Reference: CR:KG LTR/C 19005C

24th February 2020

RE: TWEED VALLEY HOSPITAL – RESPONSE TO SUBMISSIONS FOR STATE SIGNIFICANT DEVELOPMENT

Stage 2 SSD – 10353 EIS Submission:

RETAINING WALL SCHEDULE			
WALL REFERENCE	ORIGINAL SSD1 WALL REFERENCE	APPROX. LENGTH	PROBABLE MAX HEIGHT
RW01	RW04	*	*
RW02	RW01	250m	3.4m
RW03	RW02	60m	1.5m
RW04	RW02	124m	3.4m
RW05	RW06	67m	2.2m
RW06	RW03	48m	3.0m
RW07	N/A	25m	1.6m
RW08	RW06	28m	3.4m
RW09	N/A	40m	2.5m

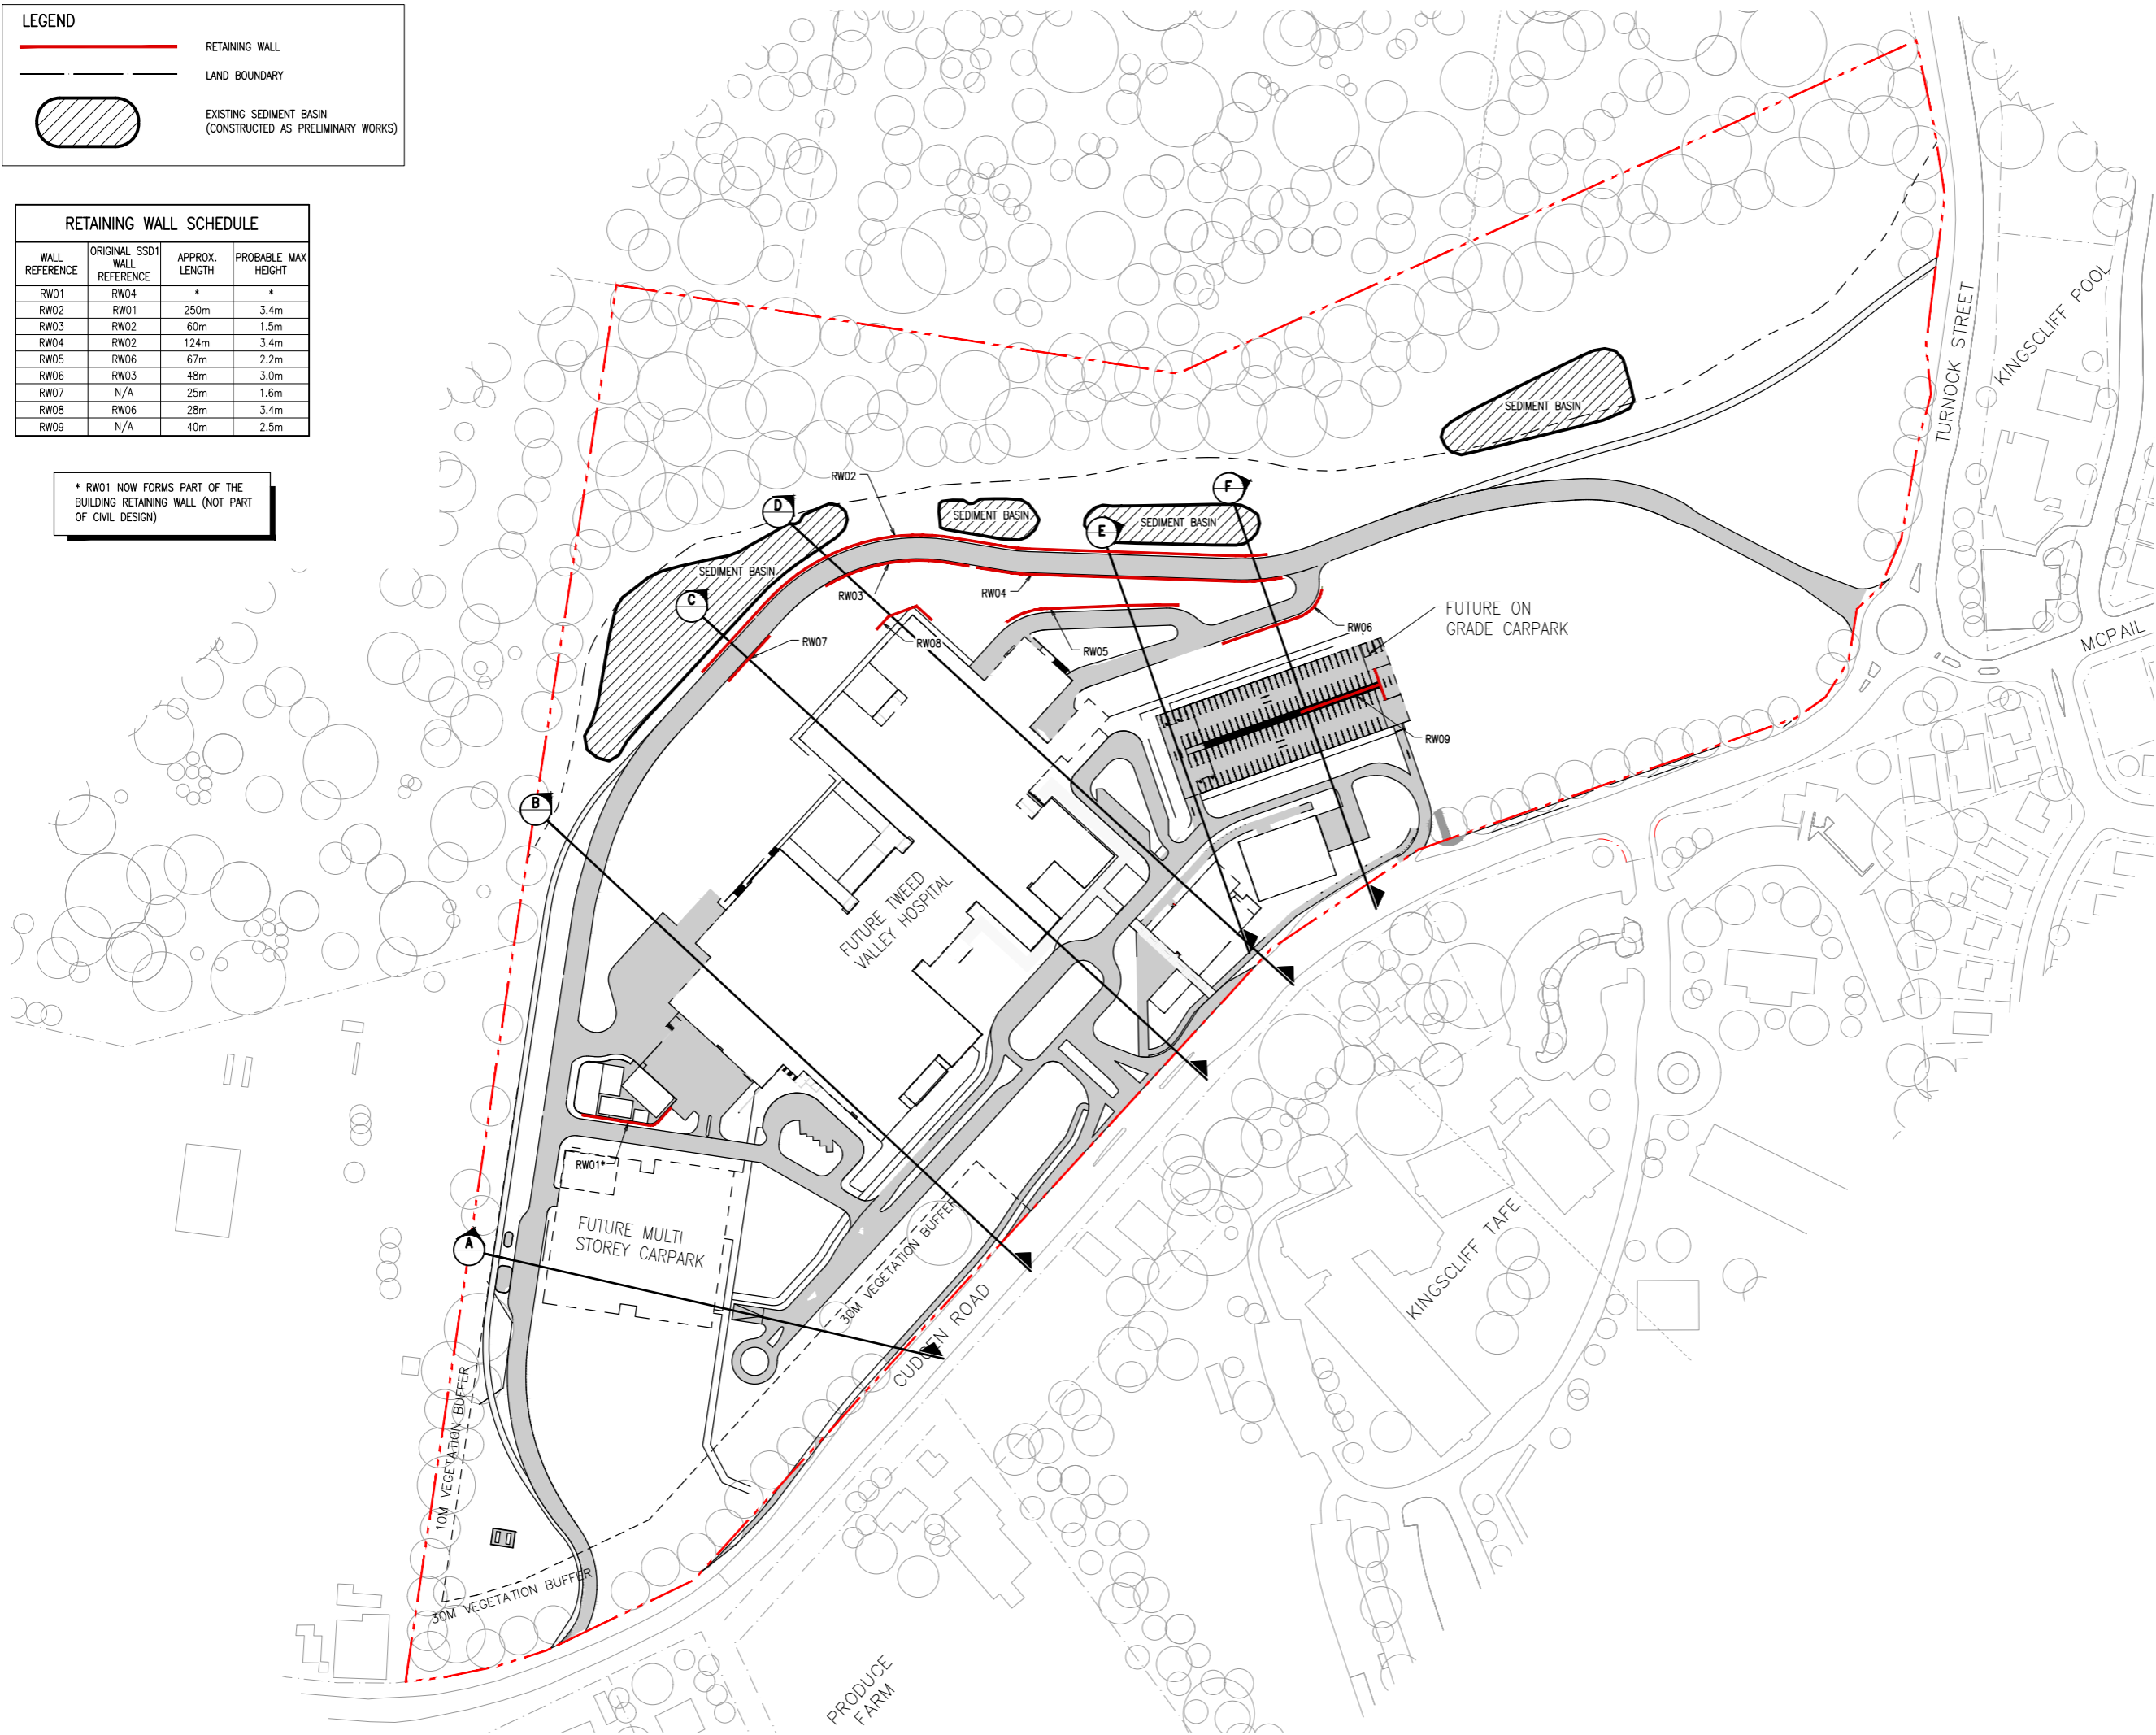
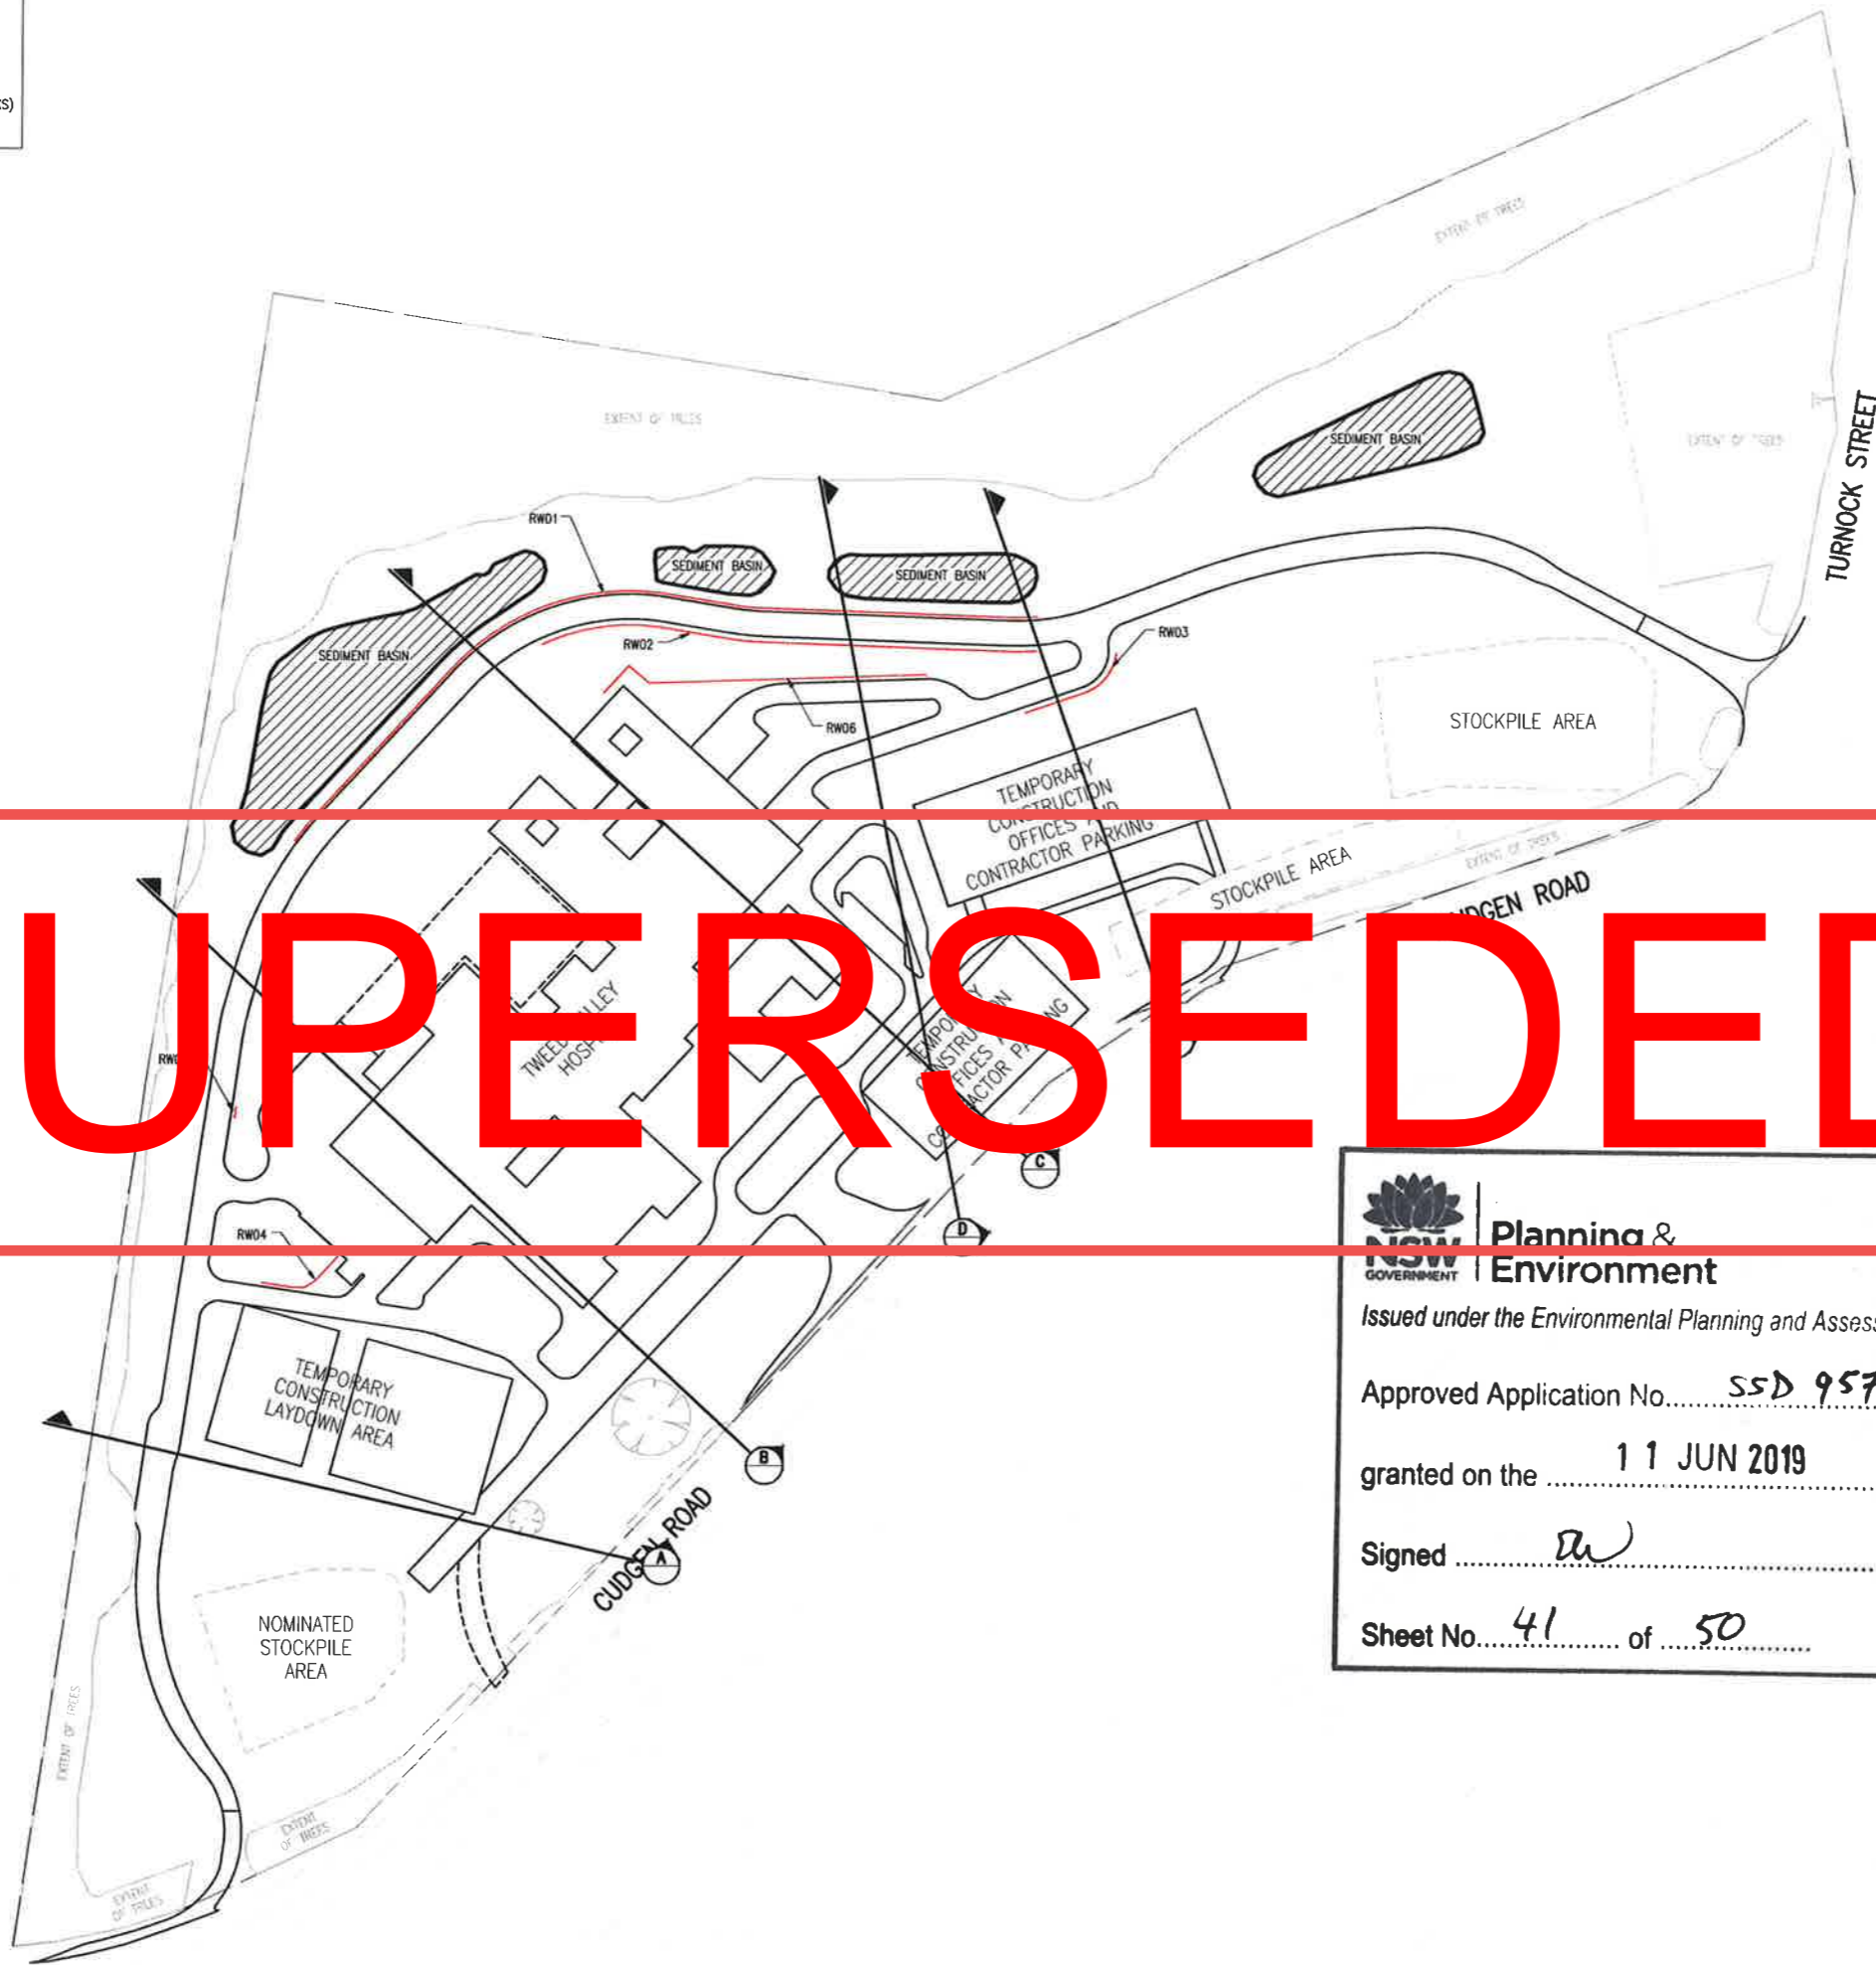
Comment: The submitted plans indicate that the amended building envelope for the hospital and the car park would result in modifications to the volume of cut and fill that was previously approved under the Stage 1 works. Having regard to the above, an amended plan should be provided that identifies the modifications to the cut and fill volumes and the need for any further retaining walls (or variation to the heights of the retaining walls) within the site.

Response: The earthworks quantities have been refined as we have developed the design of the stage 1 and 2 works, including optimising road levels, retaining walls and batter slopes. Drawings showing the cut and fill depths and retaining wall profiles are provided as annexures to this letter. The current design results in approximately 12,000m³ of material to be removed and disposed off-site.
